PLANNING AMENDMENT

H08/0089/01

Plot 1, Apple Crumble Court, off Belchmire Lane, GOSBERTON

Amendments to Living Room size
and Bedroom over (Reduction)

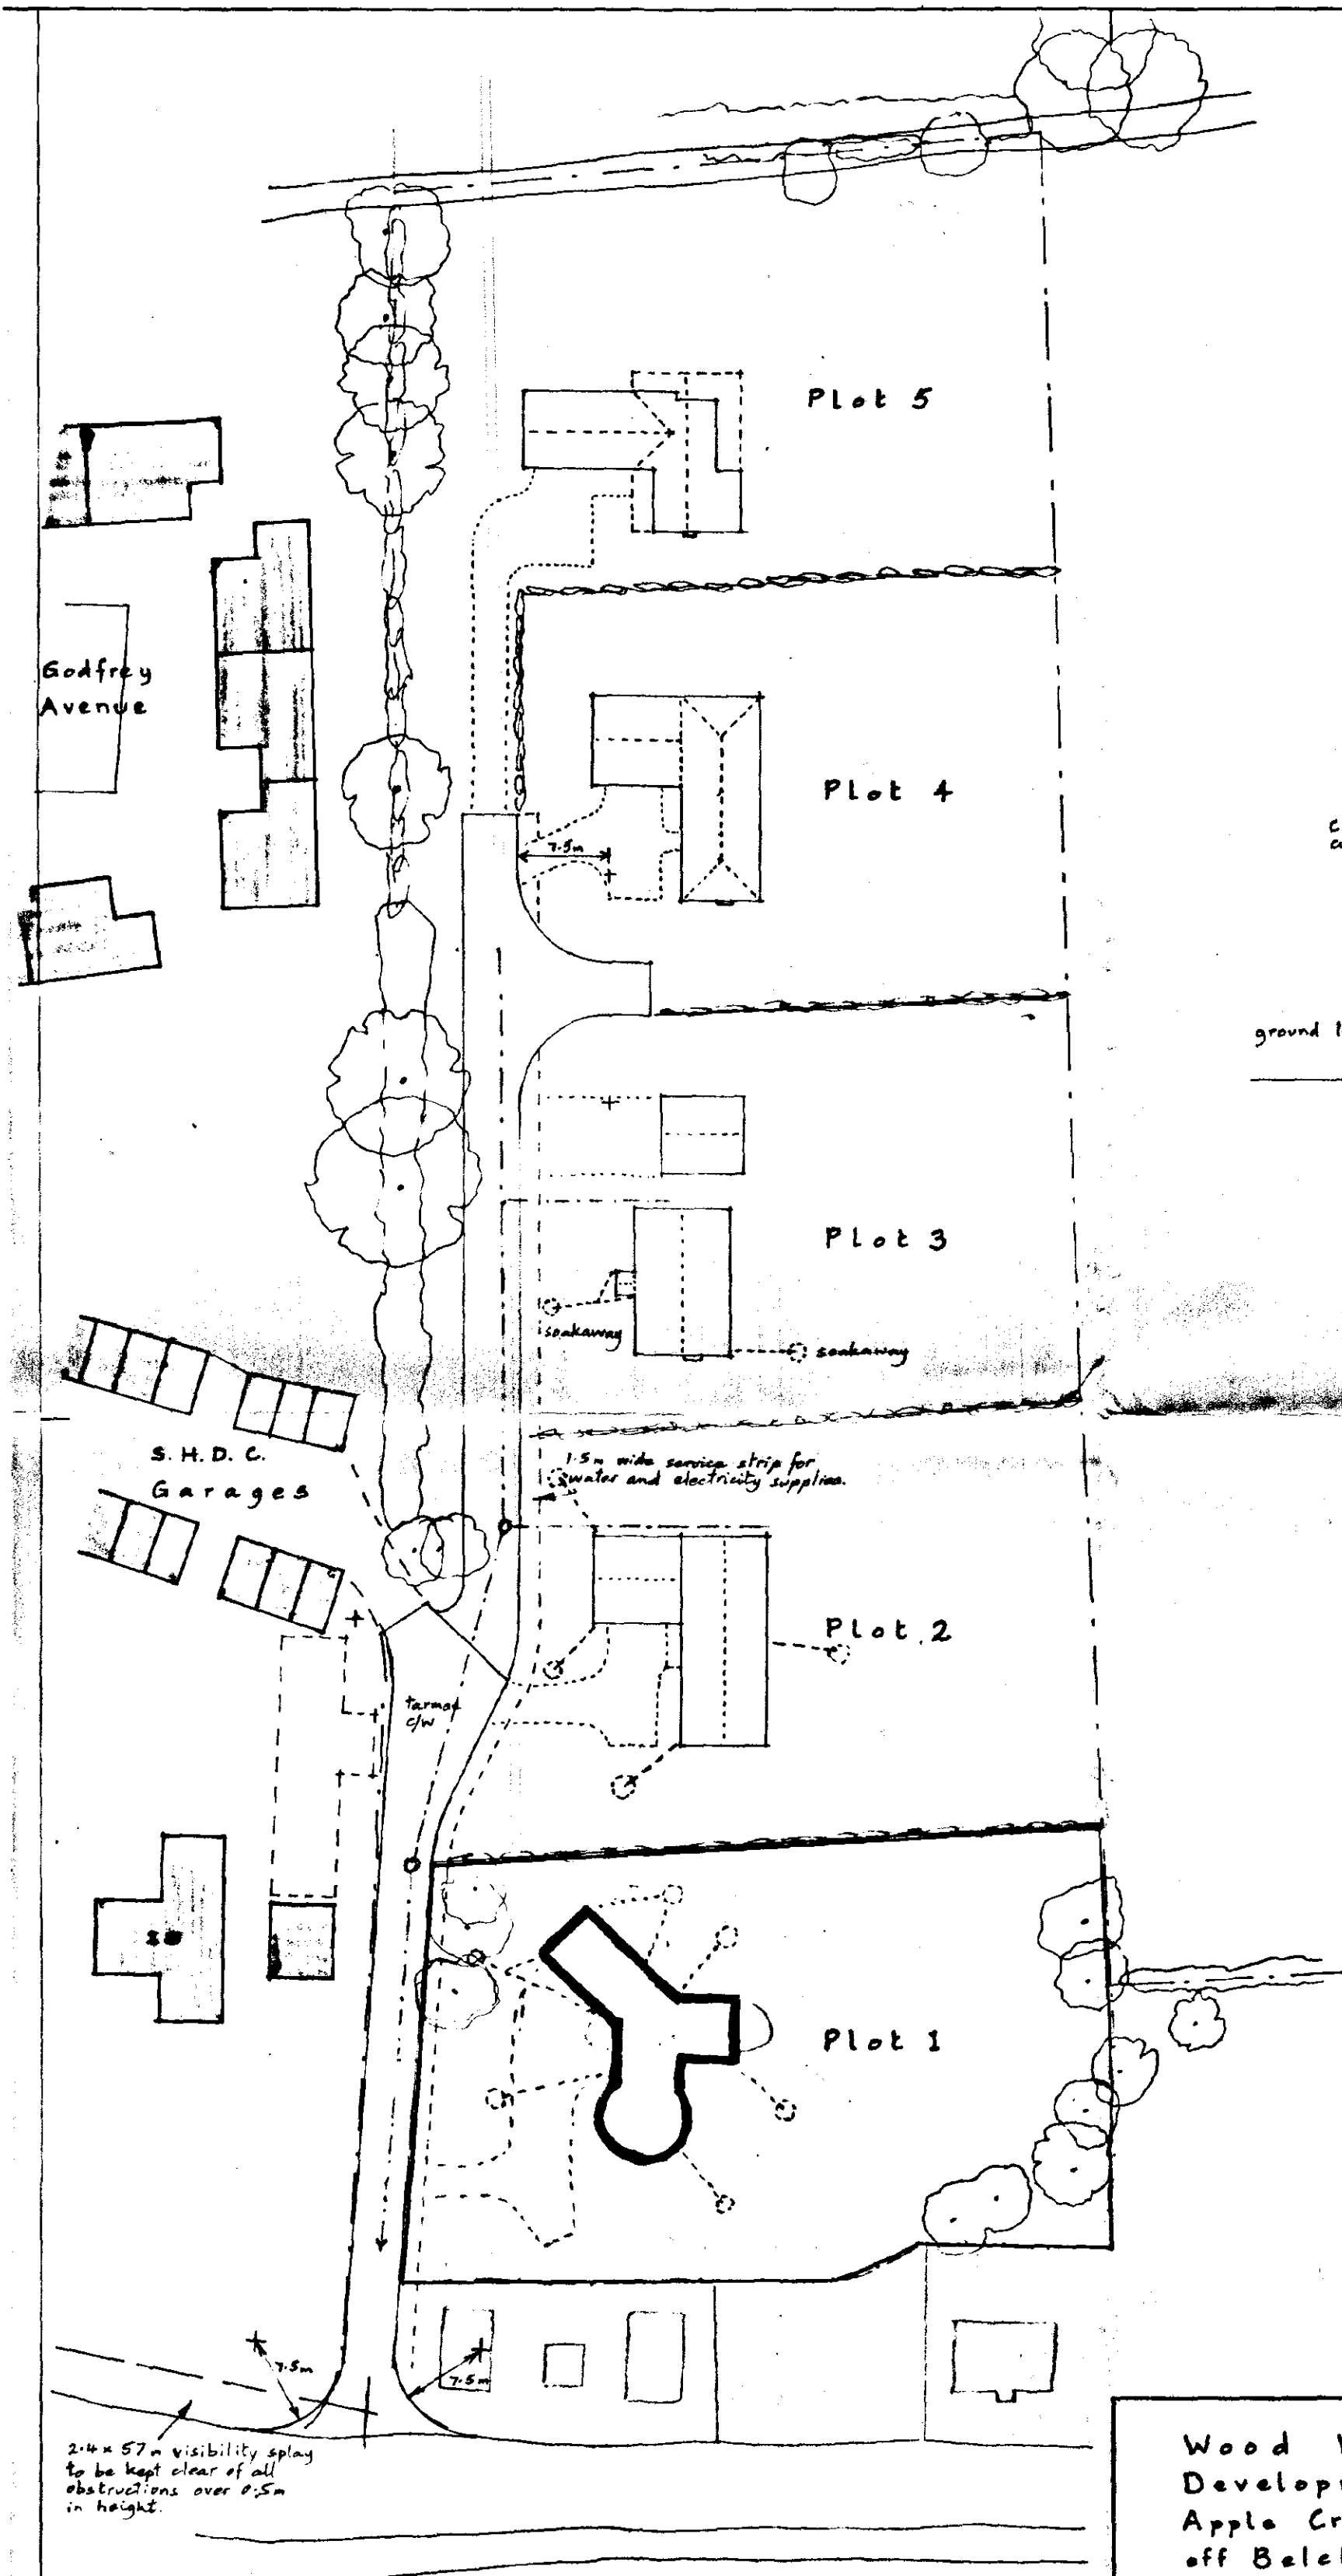
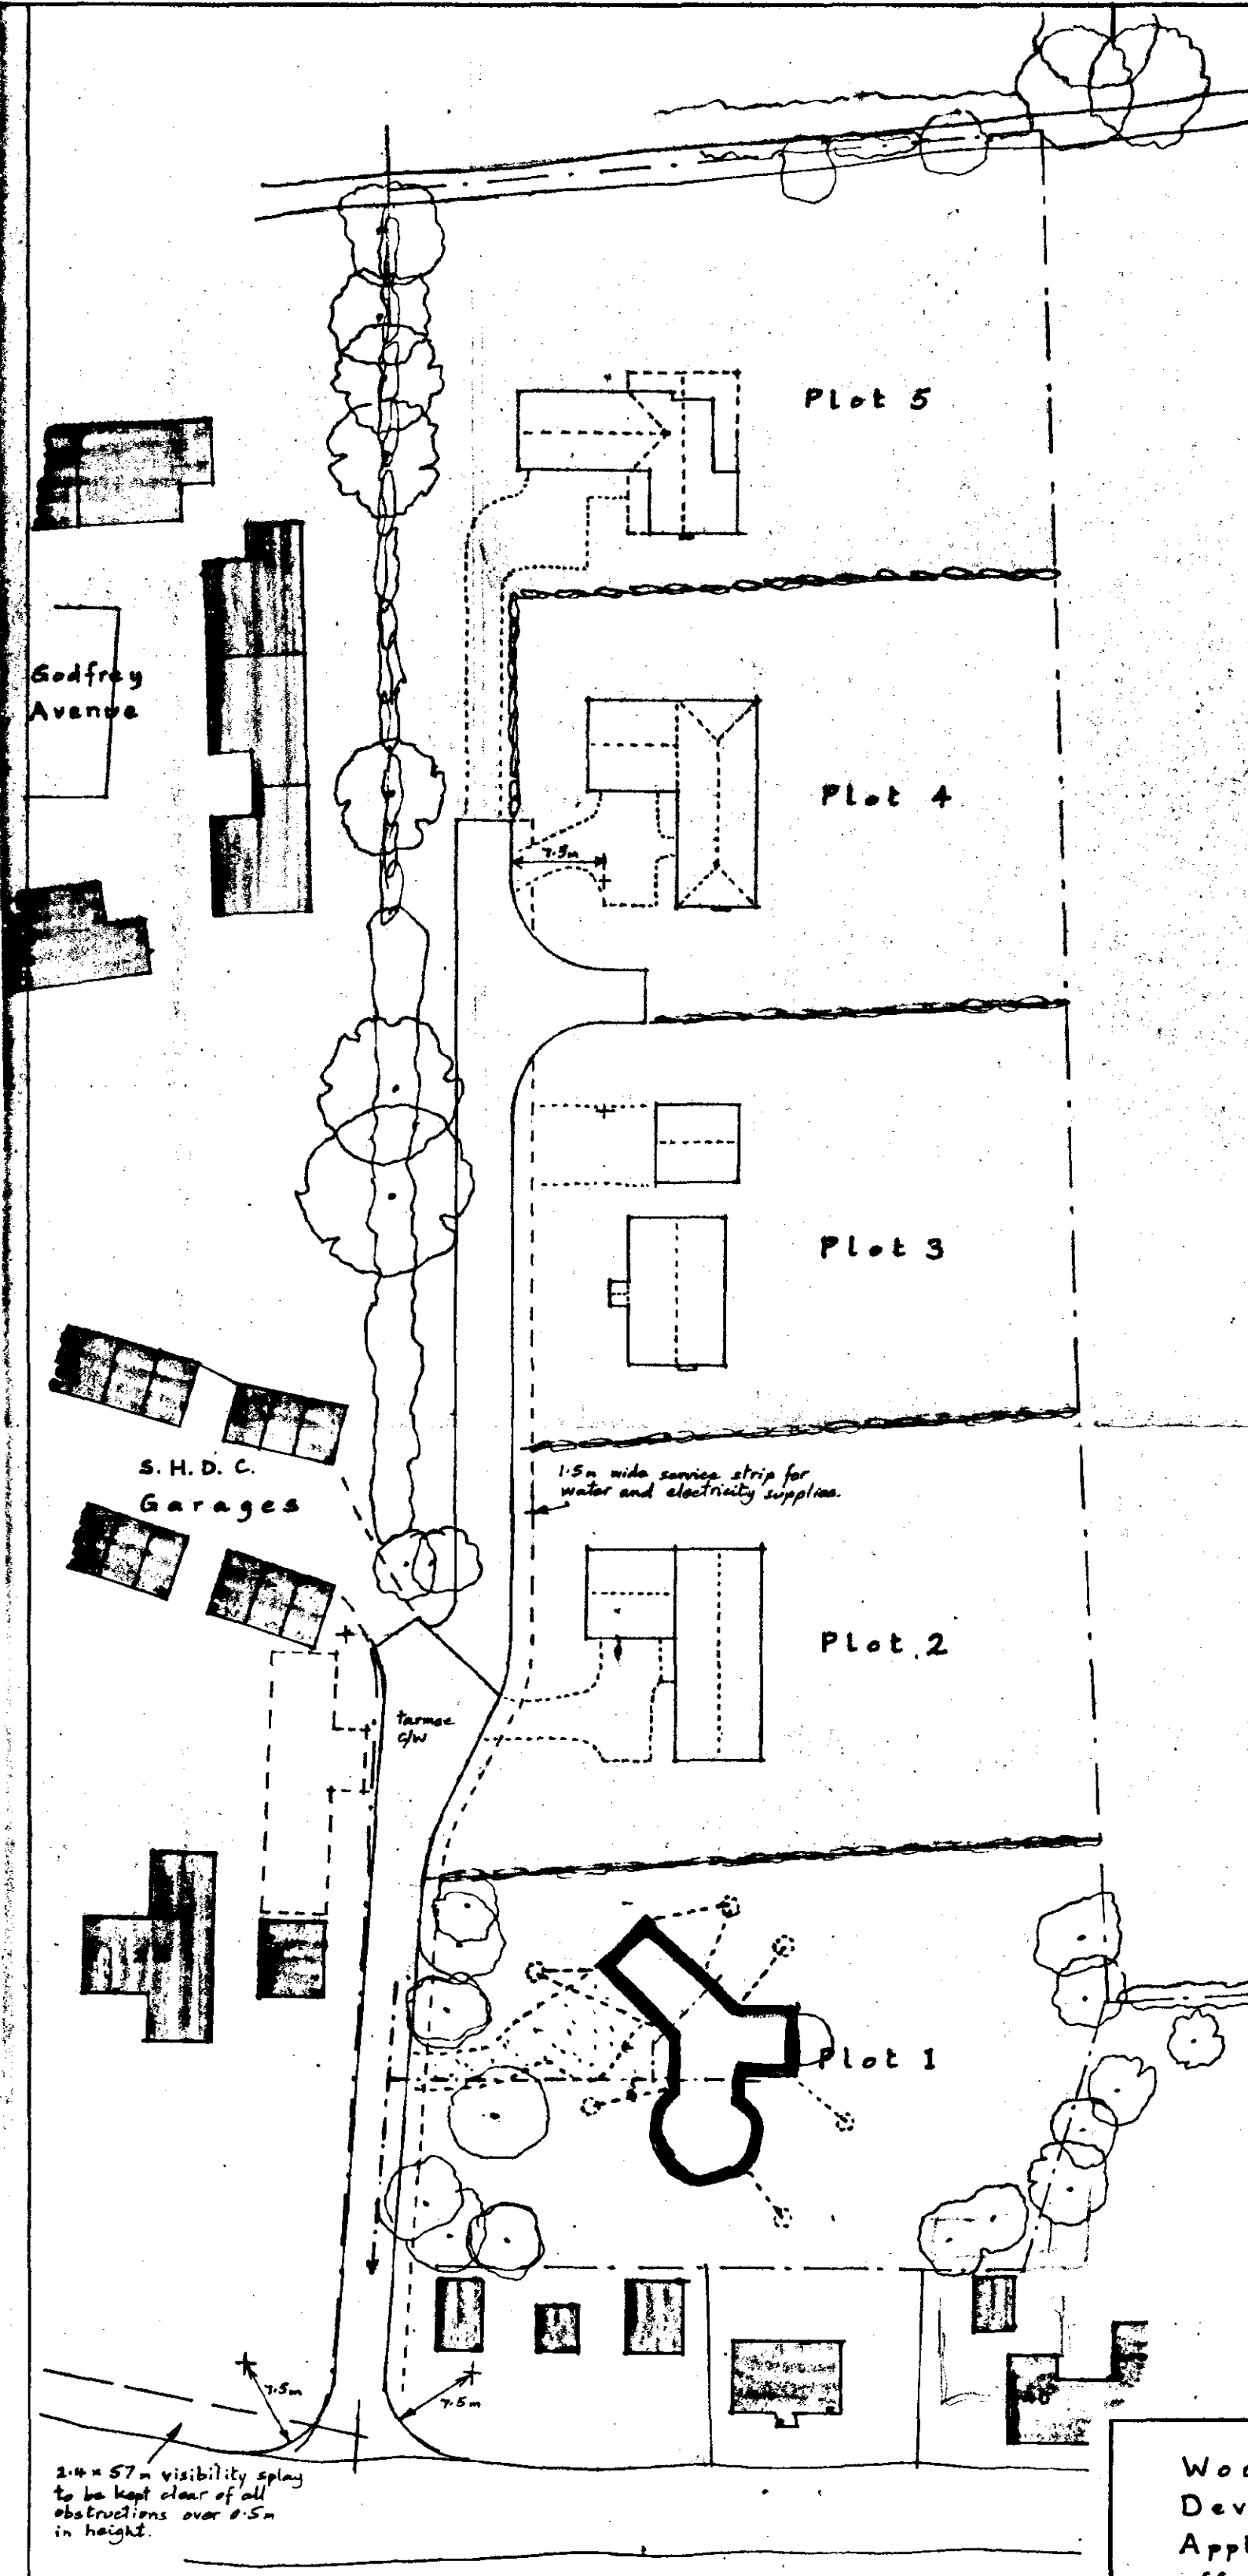
We would confirm that the distance between the house proposed by Mr Hewes and that facing Belchmire Lane will be 90 feet.
